October 17, 2024

**RE: *McDonald's – Village at Lorson Ranch Filing No. 1 Lot 2***

## **COMMENT RESPONSE LETTER**

## SIGN PROGRAM BOOK

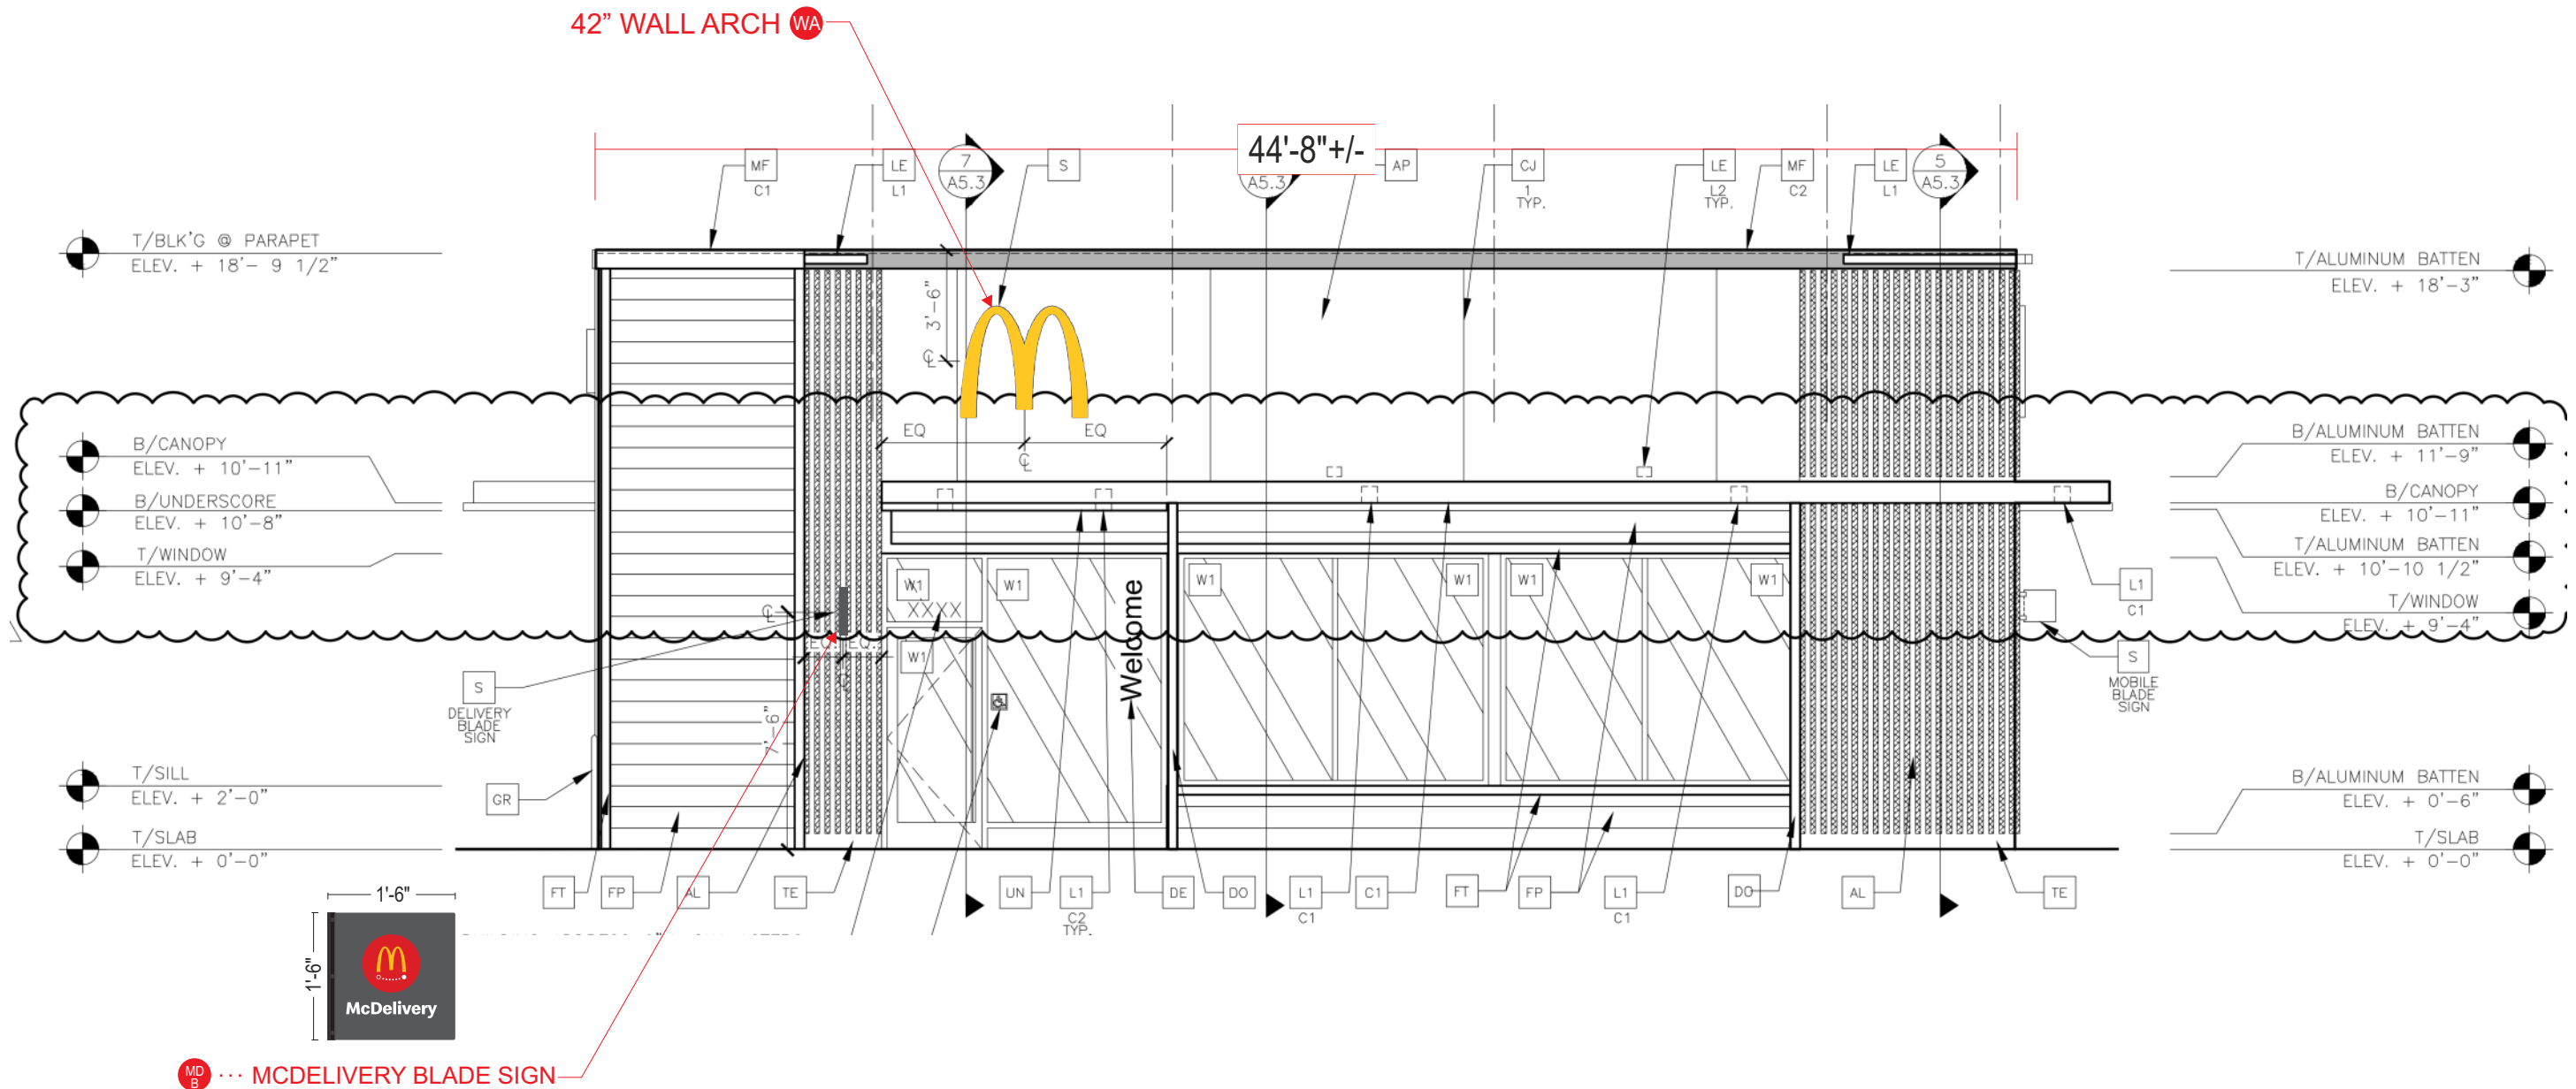
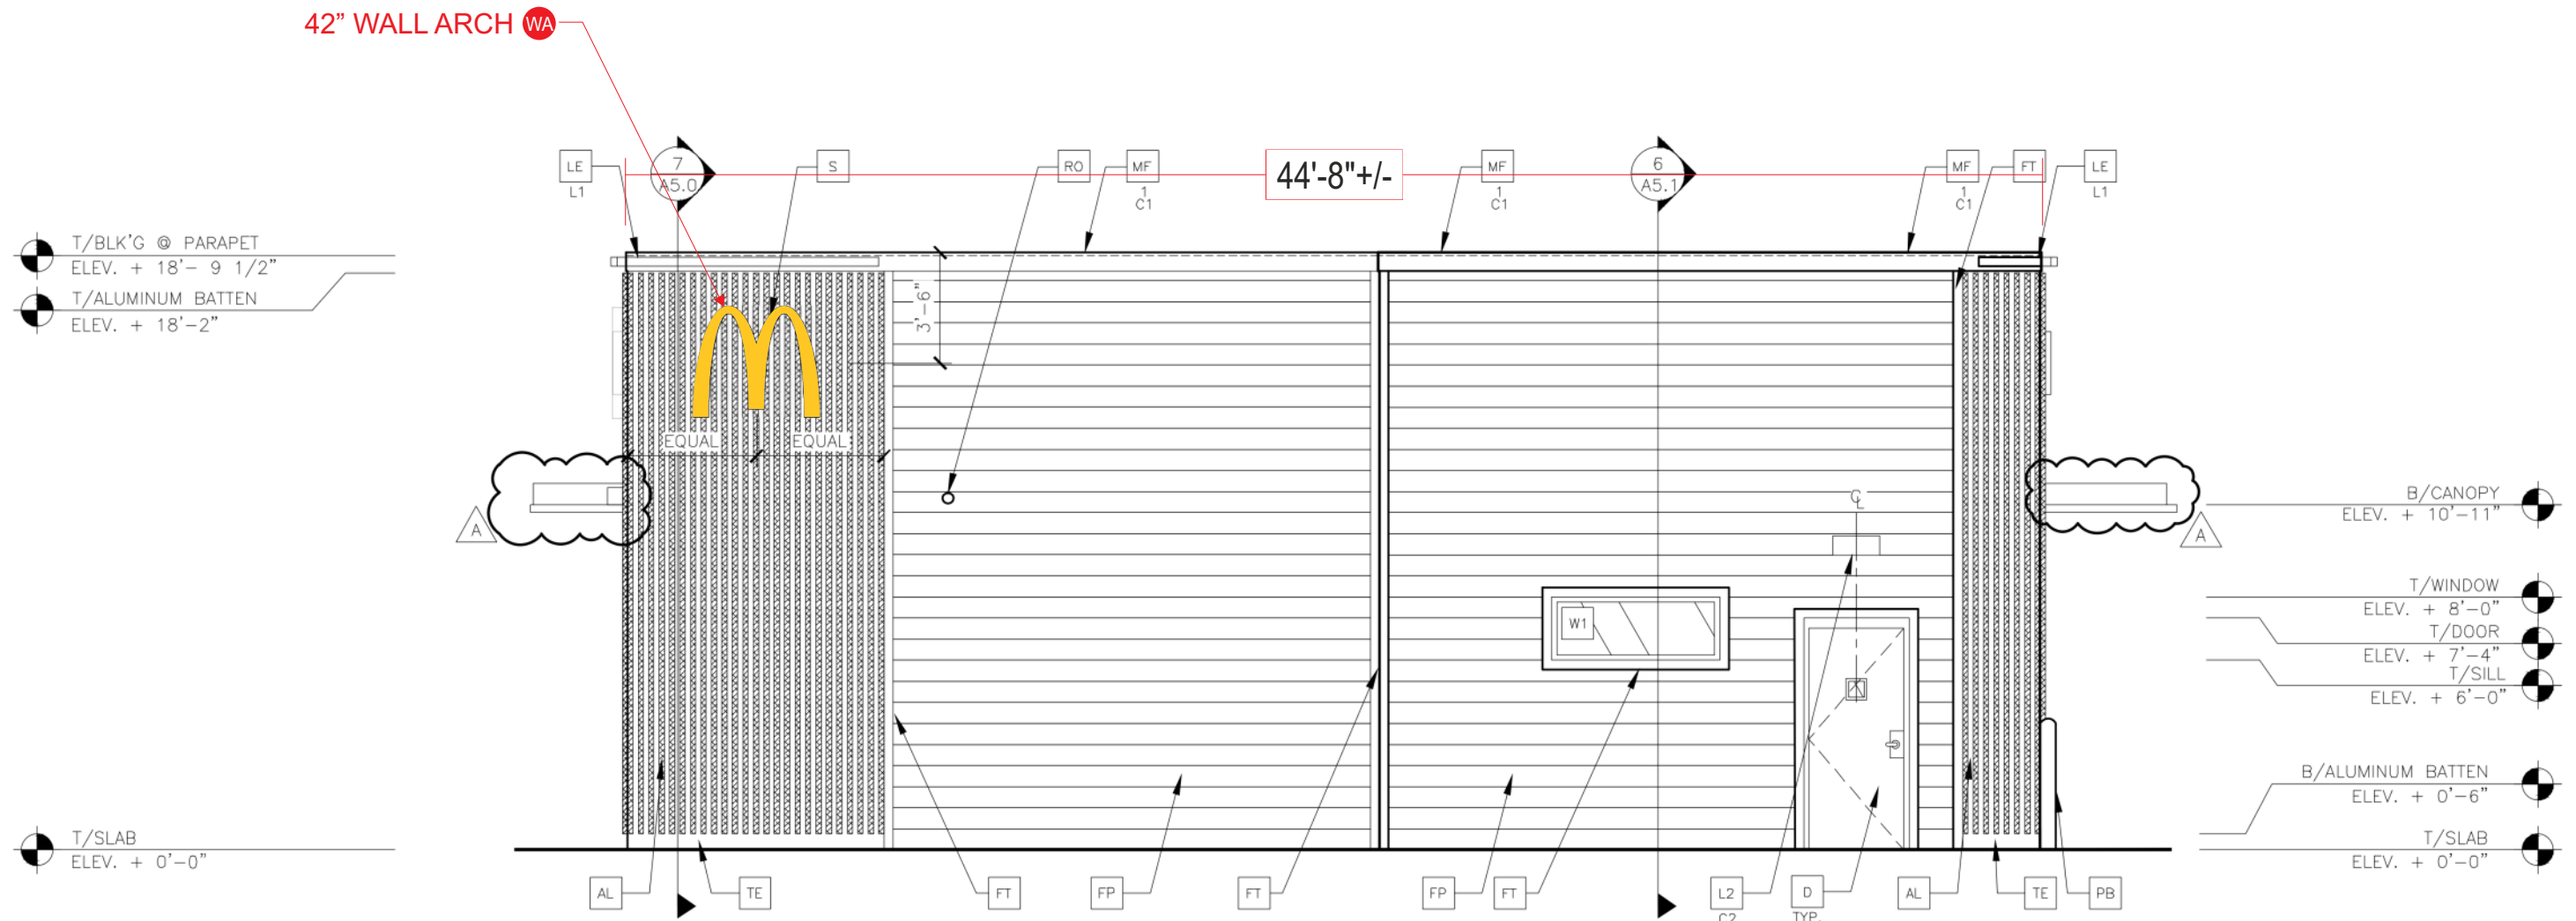
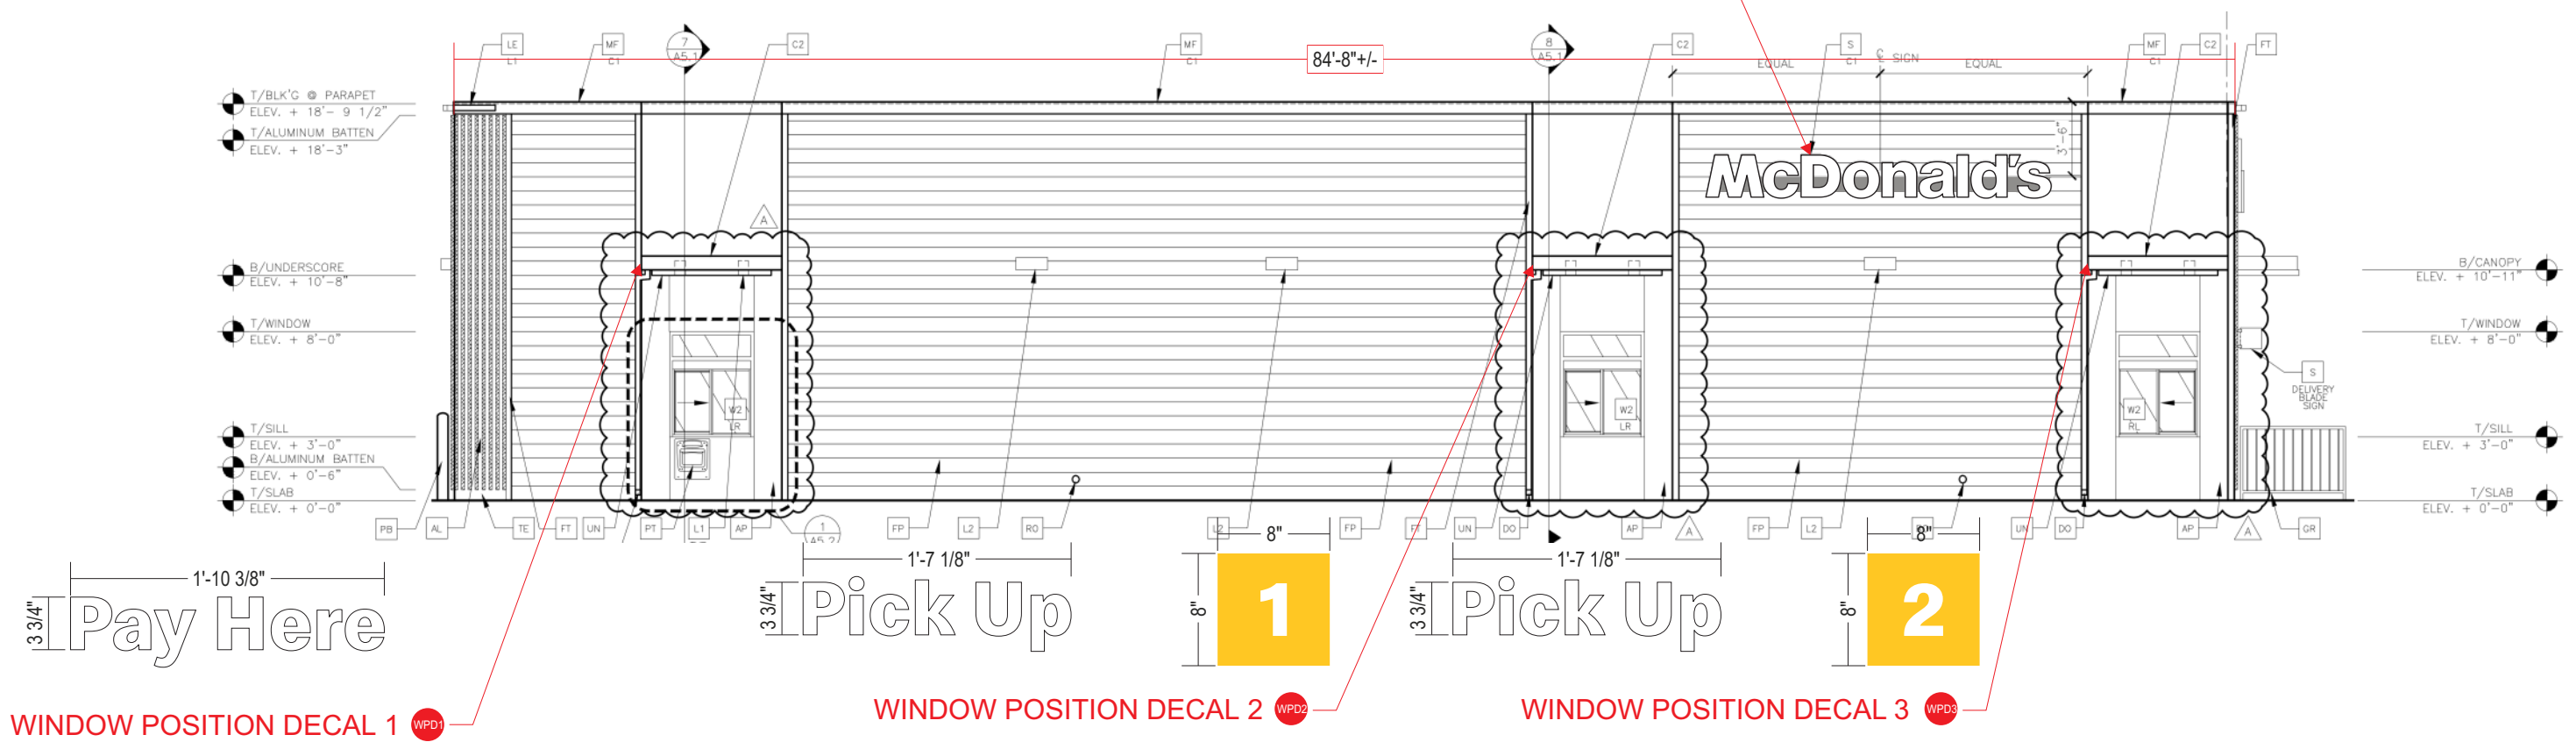
i. Please provide:

1. Summary of square footage of the total allowed signage and existing and proposed signage for the property.
2. Setback distances from all lot line to all existing and proposed signs.
3. Detailed description of illuminating devices and how the proposed illumination will be in compliance with the lighting standards.

■ **Response:** *Provided.*
